Application number: 2020/92002	
What is the application for?:	Demolition of conservatory and erection of single storey side and rear extension
Address of the site or building:	12, Moorville Drive, Birkenshaw, Bradford, BD11 2BT
Postcode:	BD11 2BT

Rear Elevation
1 : 50

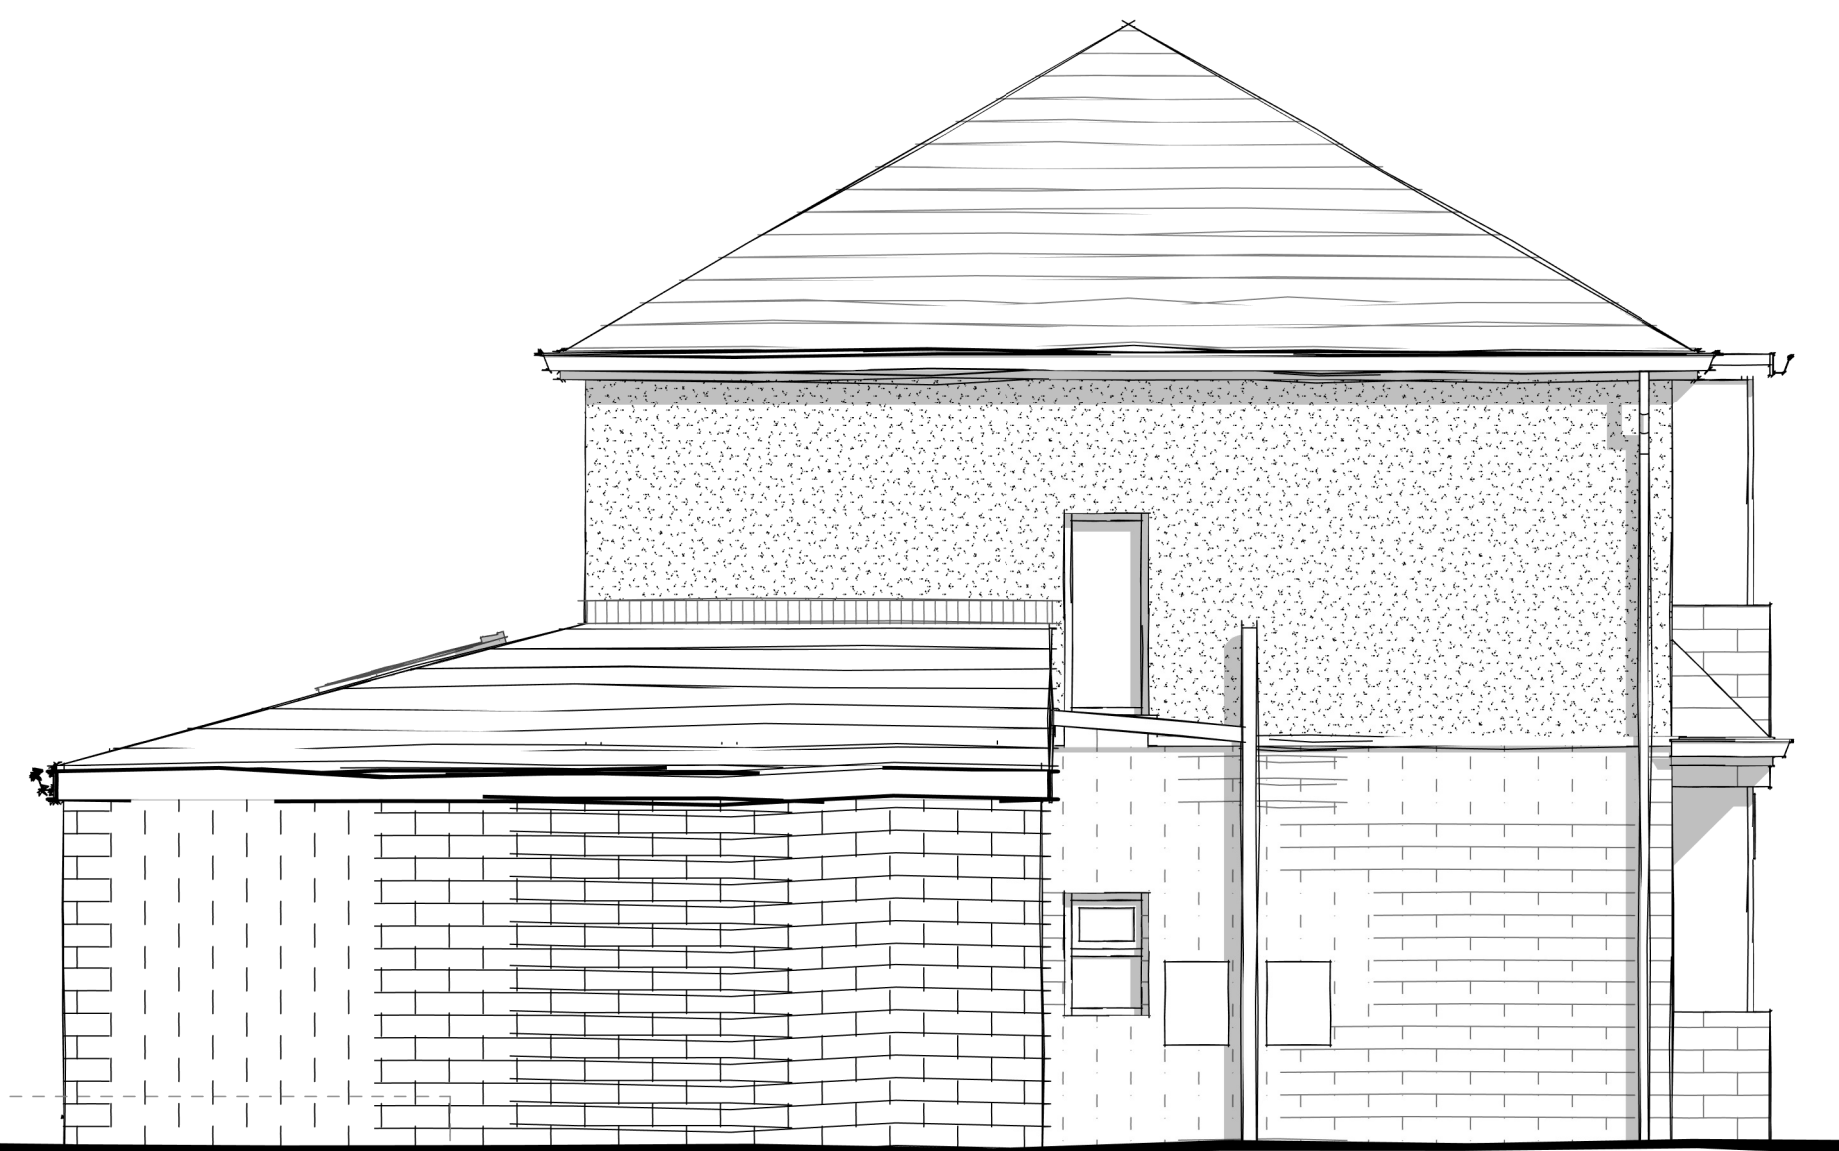
Type of comment: An objection
I have concerns about the blocking of daylight from the back of no 12 particularly in front of our garage/shed. I think it will create a dark and damp corner. Our kitchen is very small and doesn't get much light, I am worried this extension will reduce the light even as a single storey. I also have concerns about the party wall as the drawing looks like the extension is touching the wall. We only moved into our house in December 19 and had this extension been done then or in progress we might not have bought the house as it gives an enclosed feel to the property. I hope my concerns are taken into consideration and hope somebody can visit us to alleviate my concerns. Finally, my letter said I had until the 17th August to comment not the 7th August so please accept my comments.
